From: Amanda Scholes on behalf of Planning.Responses
Sent: 01 July 2020 09:57
To: Planning Scanning
Subject: FW: A/76/20/PL

From: Laura Gibbons [REDACTED]
Sent: 30 June 2020 16:35
To: Planning.Responses <Planning.Responses@arun.gov.uk>
Cc: Michael Eastham <Michael.Eastham@arun.gov.uk>
Subject: Re: A/76/20/PL

Engineers Comments Regarding Surface Water Drainage

Drawing Title: Proposed Drainage Strategy

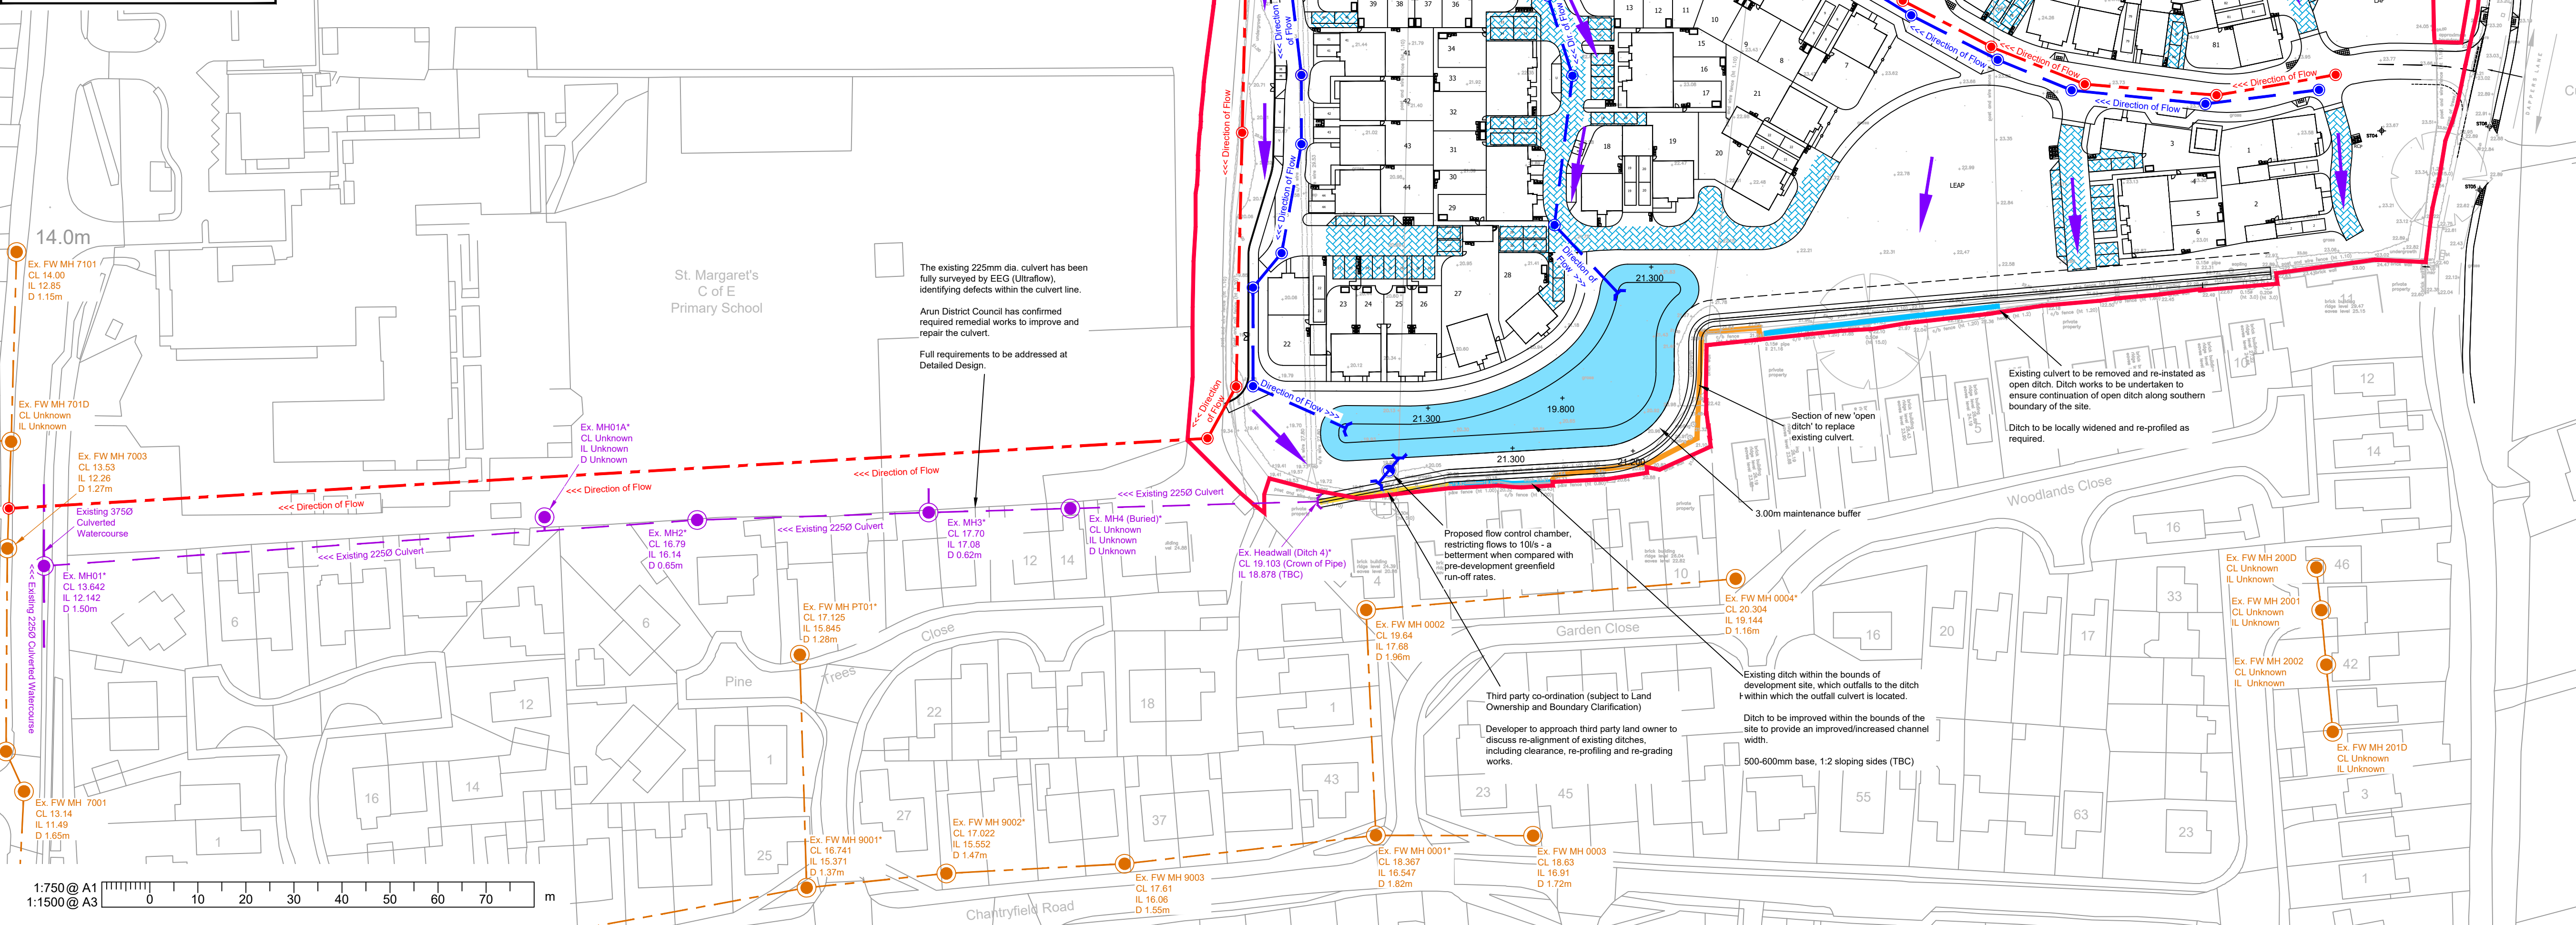
5. evidence that a 3m buffer is provided throughout the site to the southern watercourse (N.B. 3m is measured from the top of bank of watercourse).
6. Written assurances that should discharge to the watercourse be necessary that works will be completed to ensure the receiving watercourse and culvert are in an appropriate condition. These works should be in accordance with the works previously detailed in discussions with ADC and included as an appendix to the strategy submitted.

The application submitted includes a detailed surface water drainage strategy document that includes details of ground water monitoring. This monitoring indicates that groundwater is at or very near to the surface, therefore infiltration will not be viable on this site.

The proposal is for an attenuation basin and lined permeable paving to provide storage prior to discharge to watercourse or new surface water sewer. This is acceptable in principle as it follows the hierarchy for sustainable drainage, will provide adequate treatment, and provides wider benefits of SuDS such as amenity and biodiversity.

As the application seeks approval of a layout we request more details are provided at this time:

1. Catchment area plan to enable verification of provided calculations, preferably in dwg format.

2. Cross sections of attenuation basin, detailing offset of basin to surrounding features, including adjacent ordinary watercourse. An unobstructed 3m buffer should be provided around the attenuation basin.
3. Flotation calculations demonstrating that a safe basin design can be achieved in the given footprint and provide the required free volume for water storage.
4. Revisions to landscaping plans to move trees out of the attenuation basin- currently acers for example are proposed within the basin extents. This is not acceptable as the basin will have to be lined. Please ensure that all root potential areas are outside of surface water drainage feature extents.
